Babergh District Council submission to procedural deadline 1

This is the submission of Babergh District Council to deadline 1 of the examination for the North Falls Offshore Wind Farm project (EN010119). It consists of Babergh District Councils' Local Impact Report, expanding on those issues identified in the relevant representations submission of Babergh District Council to the examination.

1. Babergh District Council Local Impact Report (LIR):

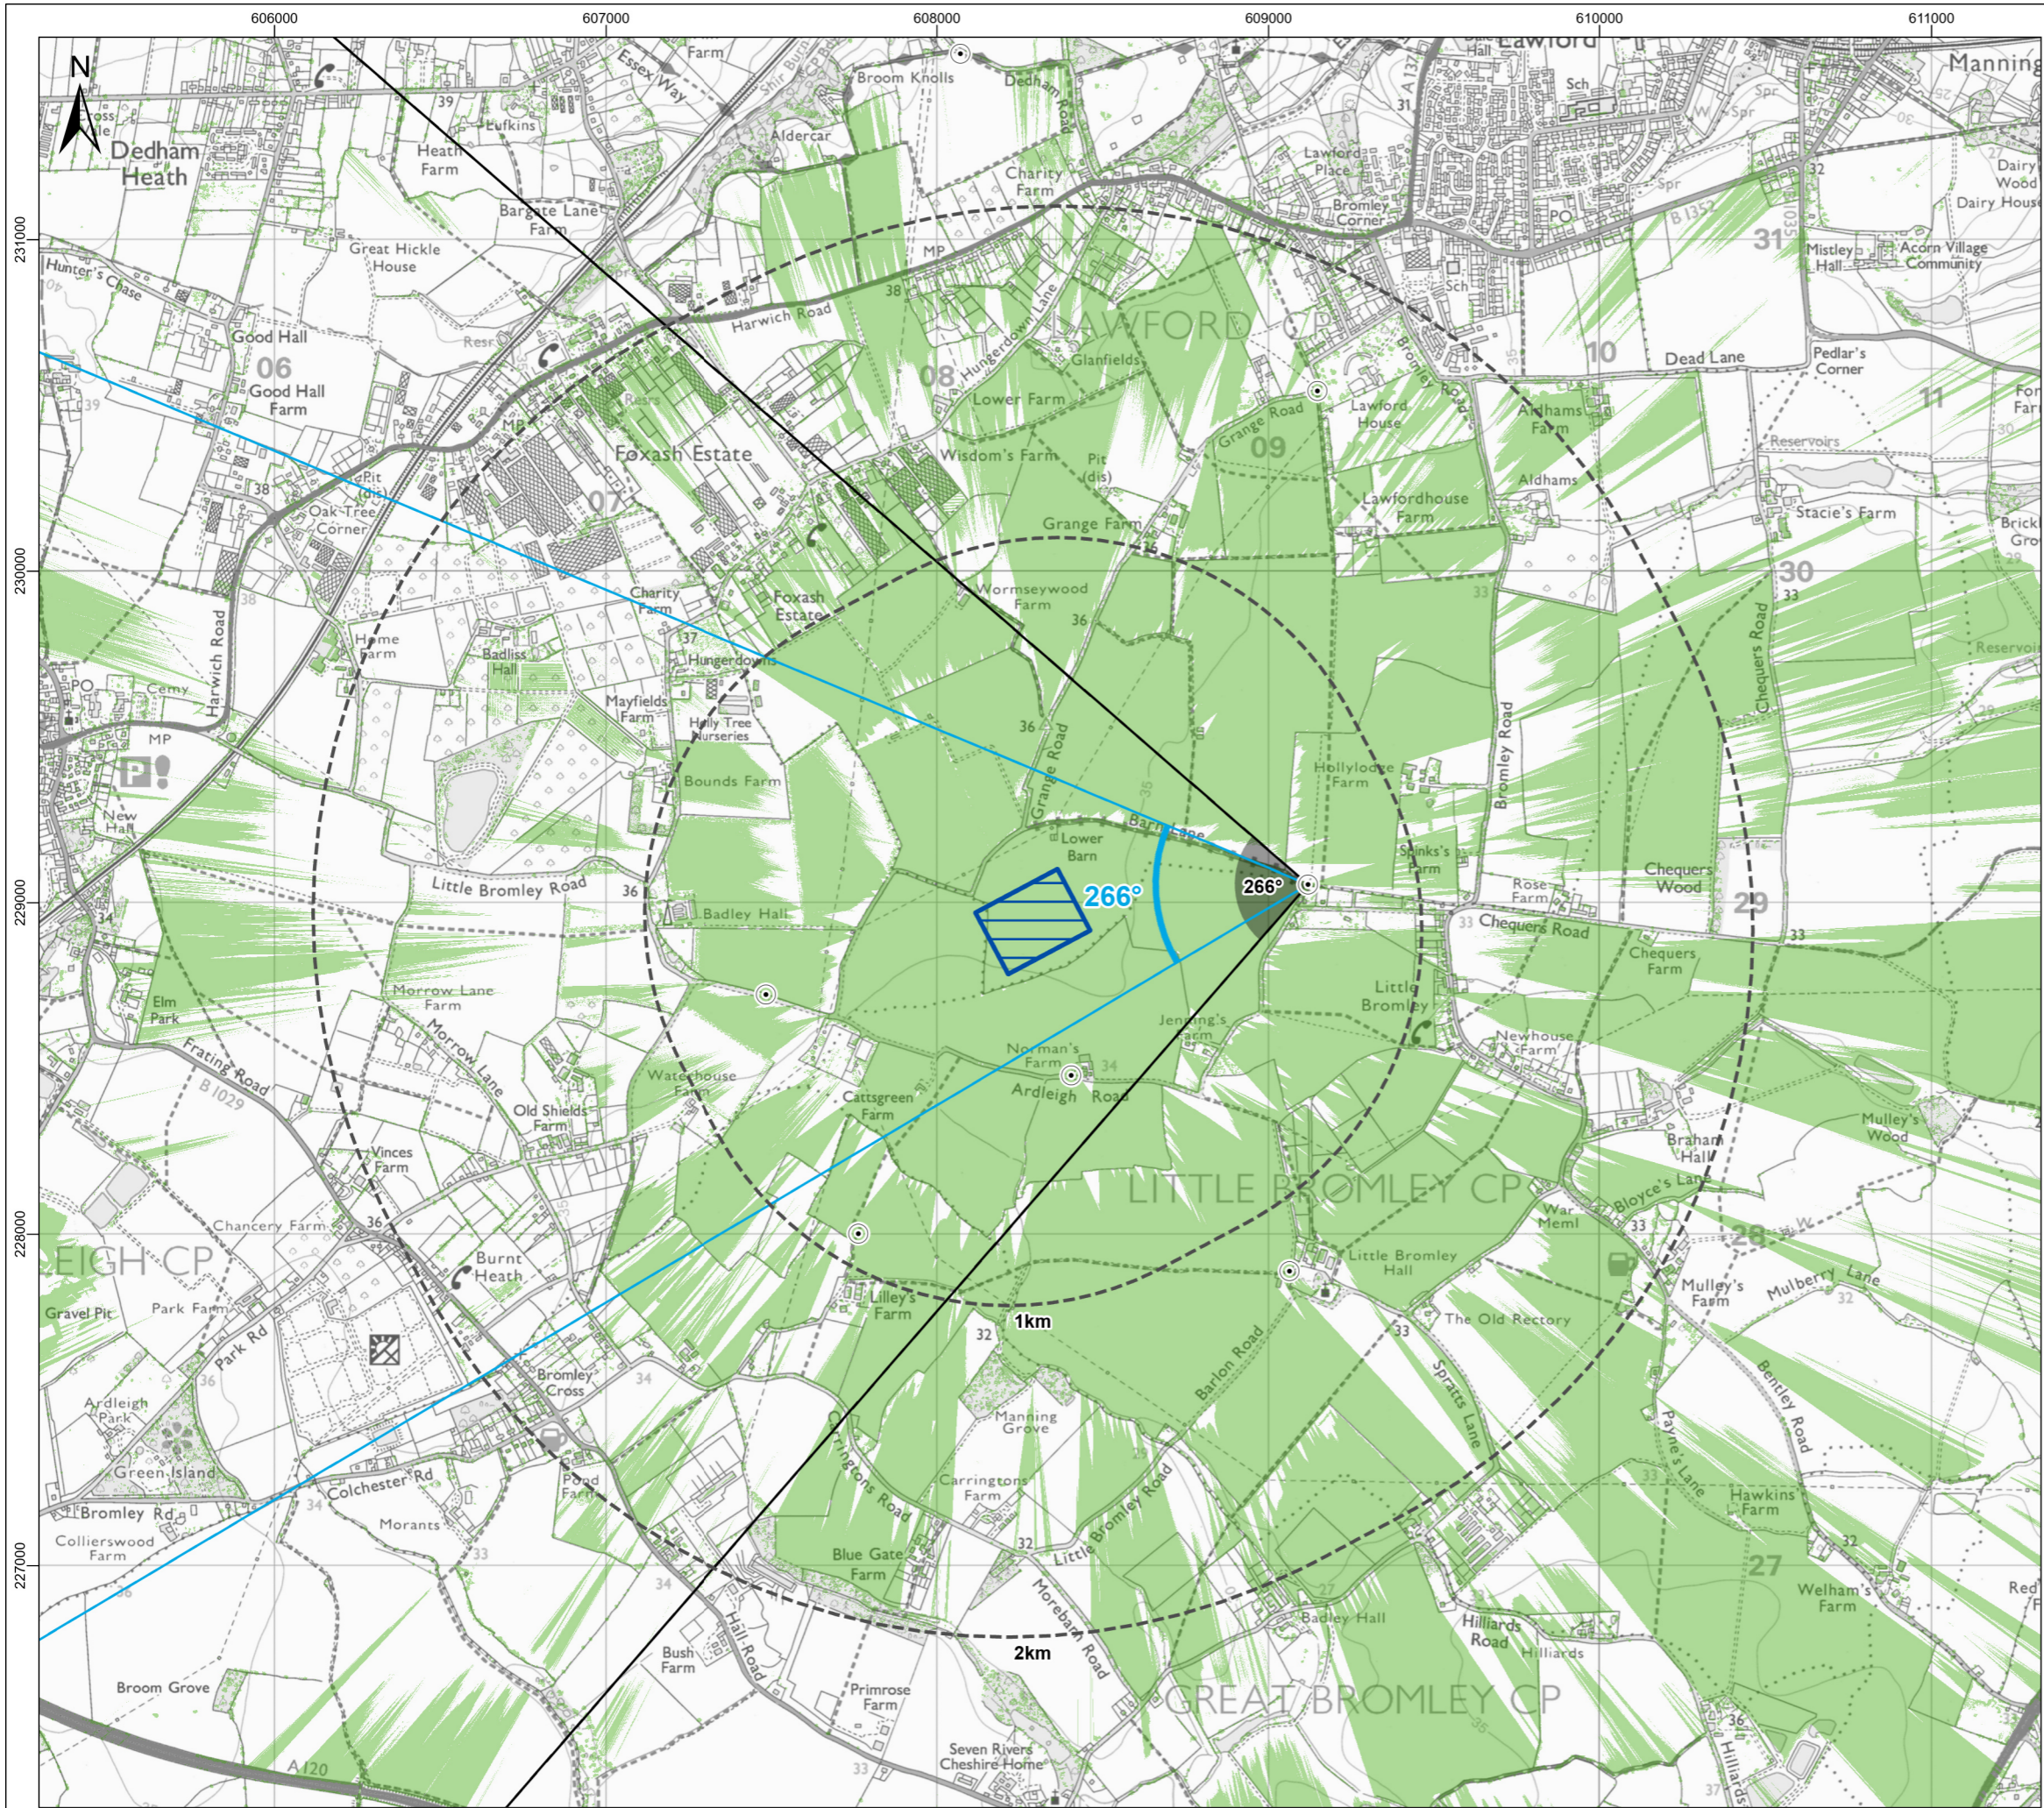
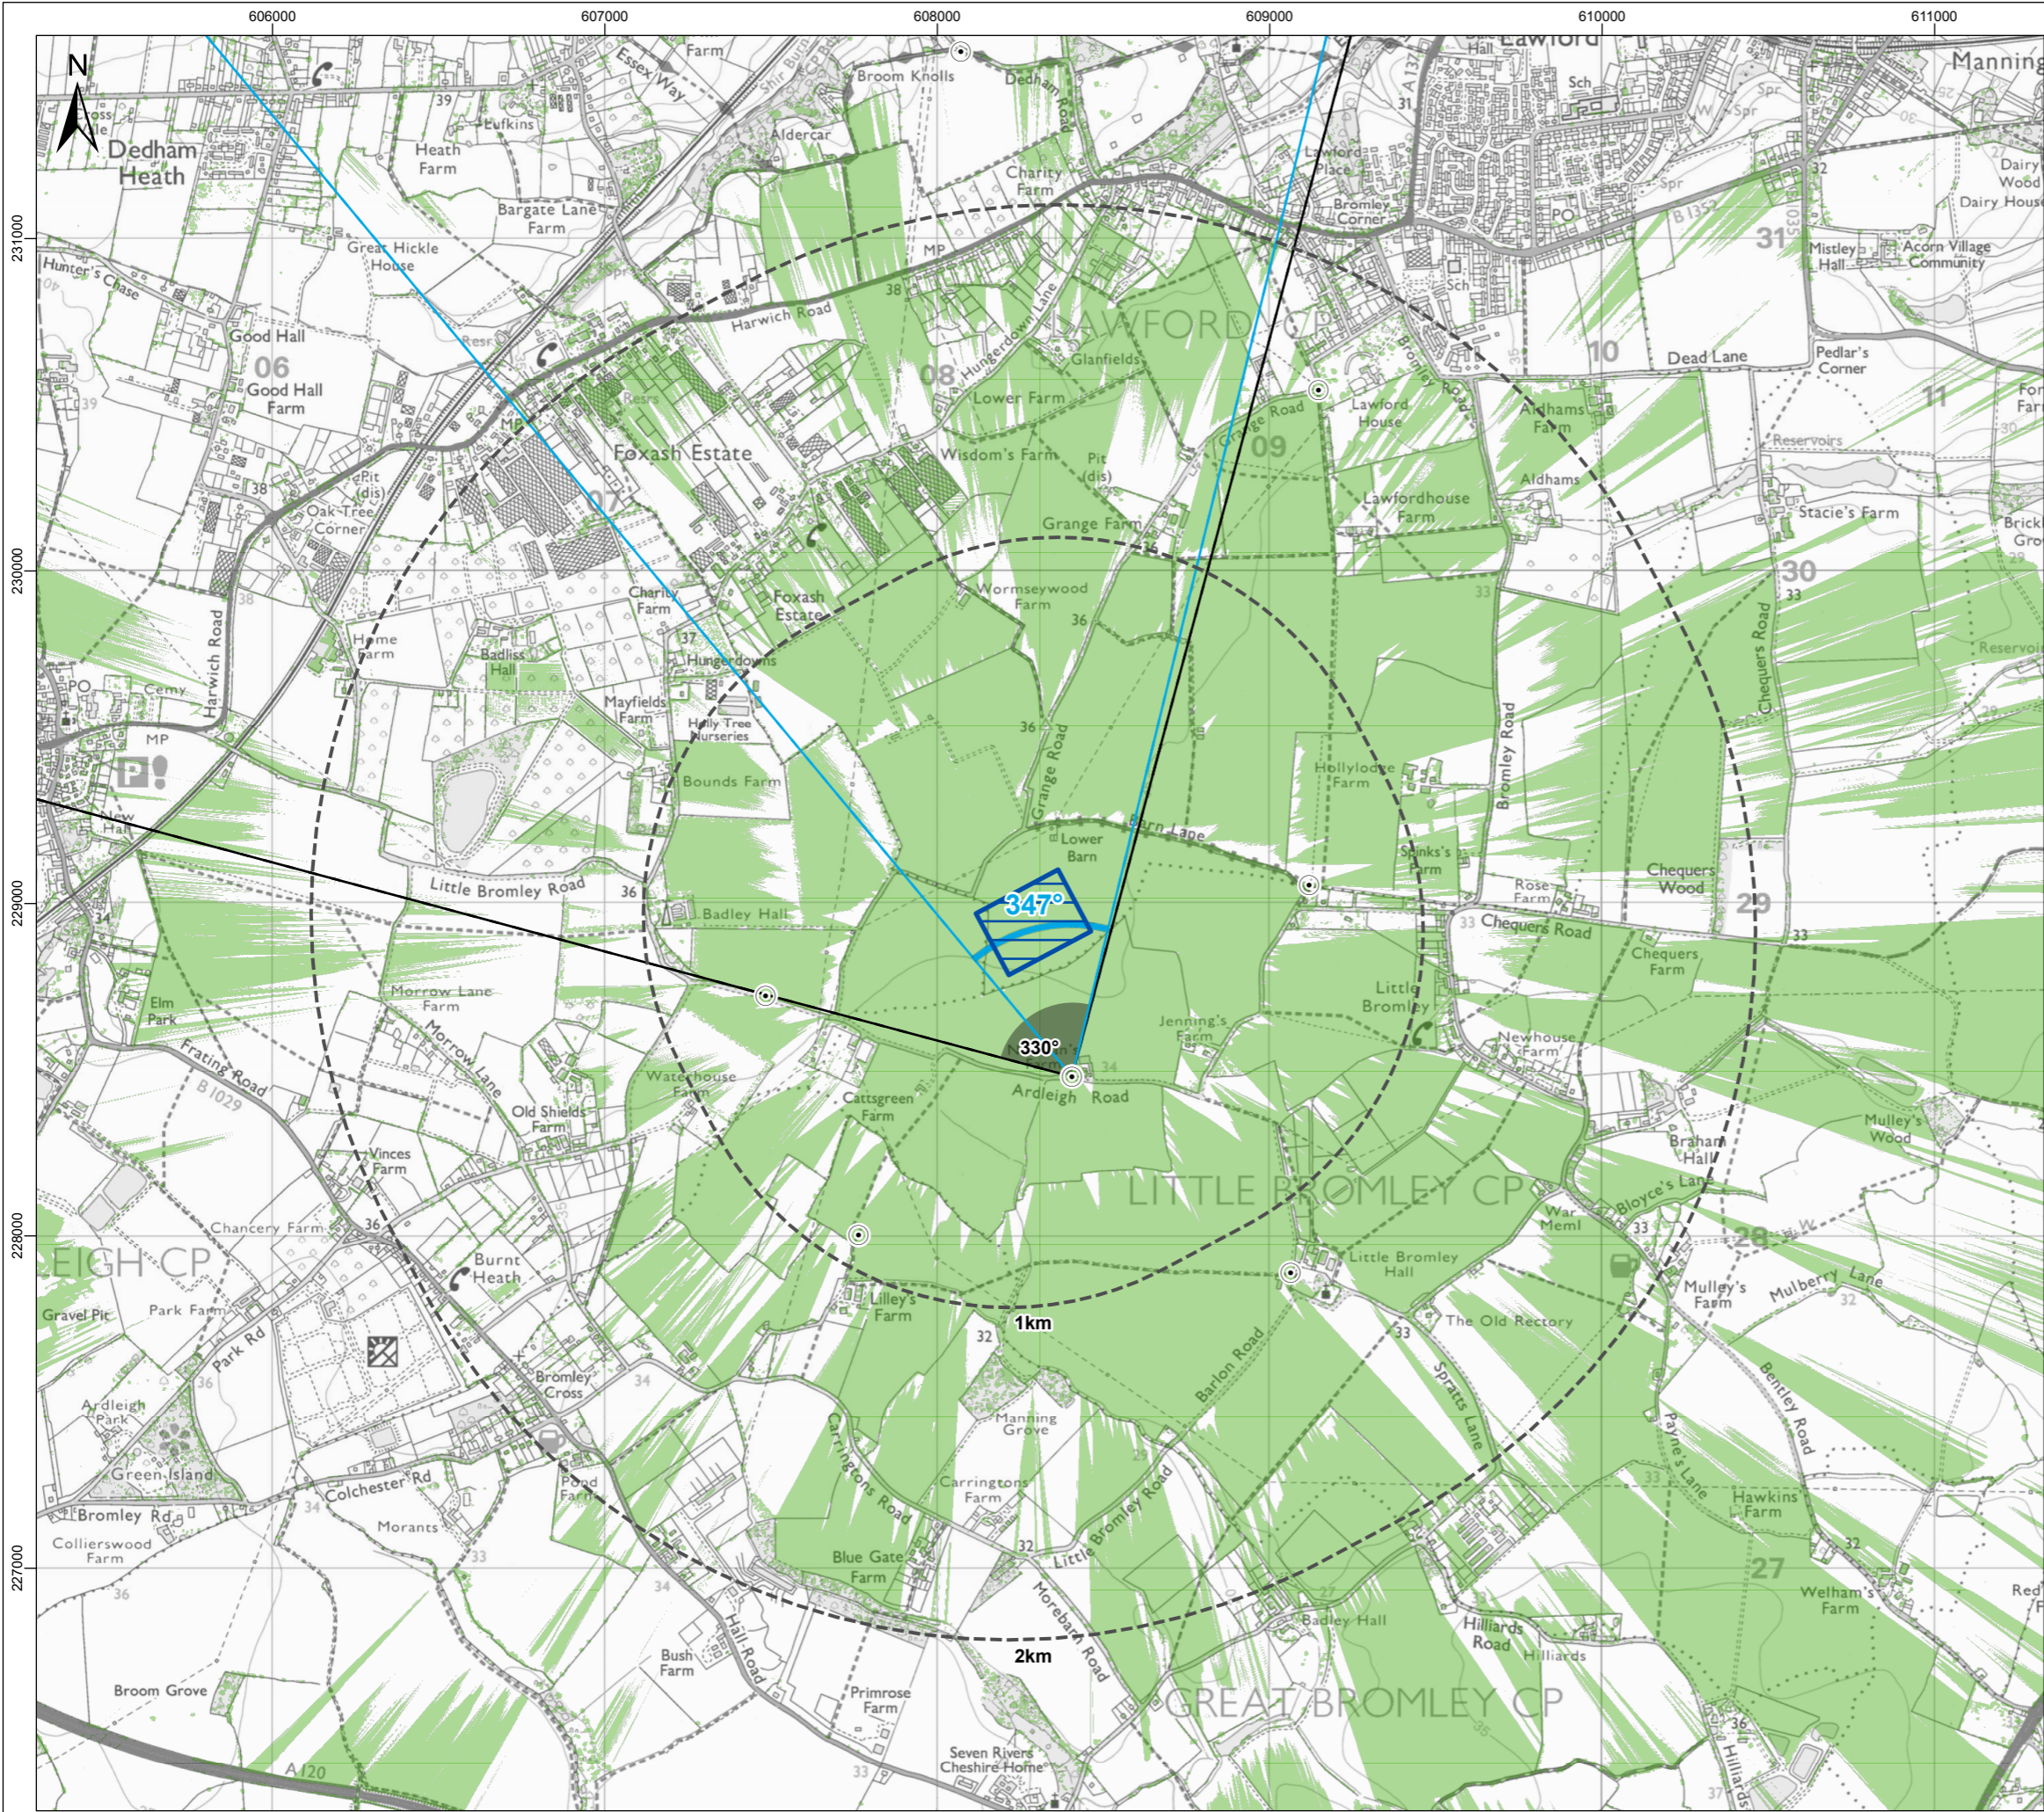
- 1.11 There are concerns that the cumulative effects of North Falls with the proposed Five Estuaries onshore substation, the East Anglian Connection Node (EACN), and the pylons that are proposed to connect to it from the Norwich to Tilbury (N2T) scheme would have a residual adverse cumulative effect on both visual receptors, the National Landscape or its setting.

- 1.12 The N2T pylons do not appear to be identified in the cumulative LVIA visualisations, and therefore it is assumed they haven't formed part of the LVIA cumulative impact assessment itself. The pylons will form part of the DCO for the Norwich to Tilbury project, along with the EACN so their cumulative impact needs to be considered.
